January 17, 2019

RE: **Enterprise Rent-a-Car**
3500 Coors Blvd NW
Conceptual Grading and Drainage Plan
Engineer's Stamp Date: 1/11/19
Hydrology File: G11D038

Based on the submittal received on 1/11/19, the Conceptual Grading and Drainage Plan is approved for Site Plan for Building Permit. Based on the information provided, Hydrology does not anticipate drainage infrastructure on this project.

SHEET NO.: C2.1
OF: 1

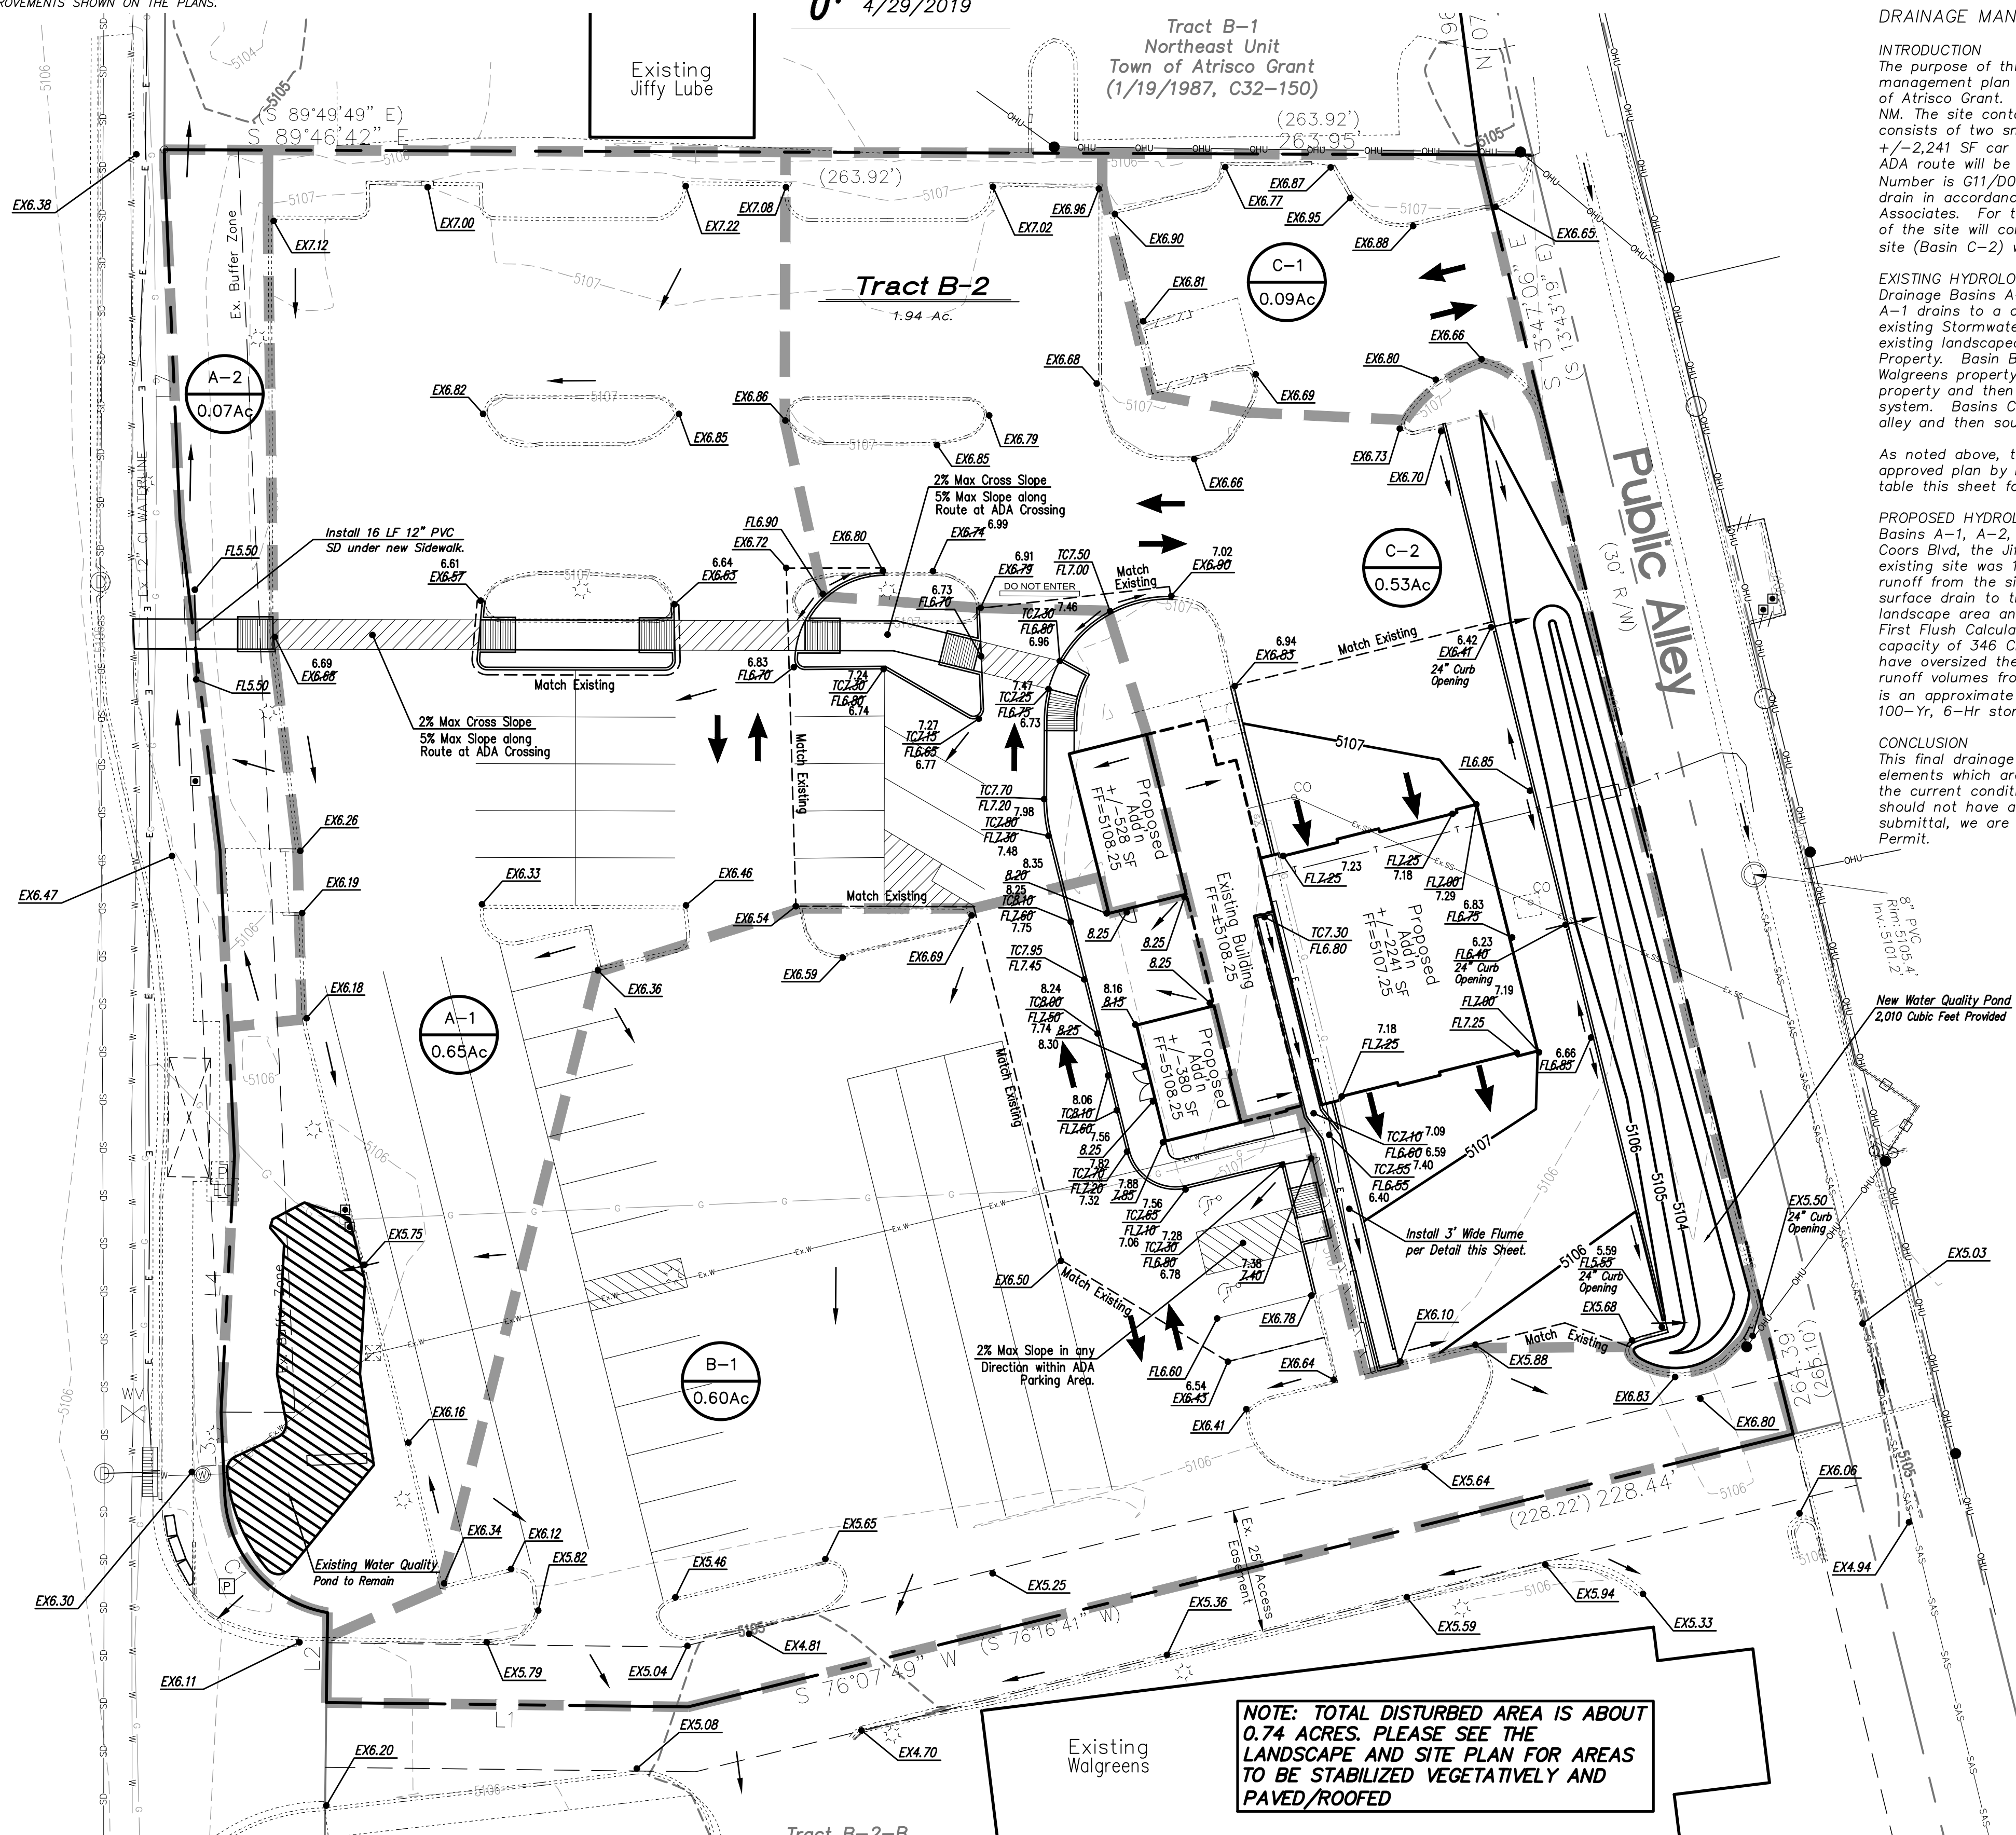
1. Remove all "Conceptual" markings.
2. Quantify the area of redeveloped impervious (repaving and the building addition) and the area of disturbance.
3. Calculate the Storm Water Quality Volume (SWQV) requirement, based on the redeveloped impervious area. Demonstrate that the new stormwater pond will capture the equivalent stormwater quality volume from impervious areas.
4. If the disturbed area will exceed 1 acre, this project will require an ESC Plan, submitted to the Stormwater Quality Engineer (Curtis Cherne PE, ccherne@cabq.gov or 924-3420).
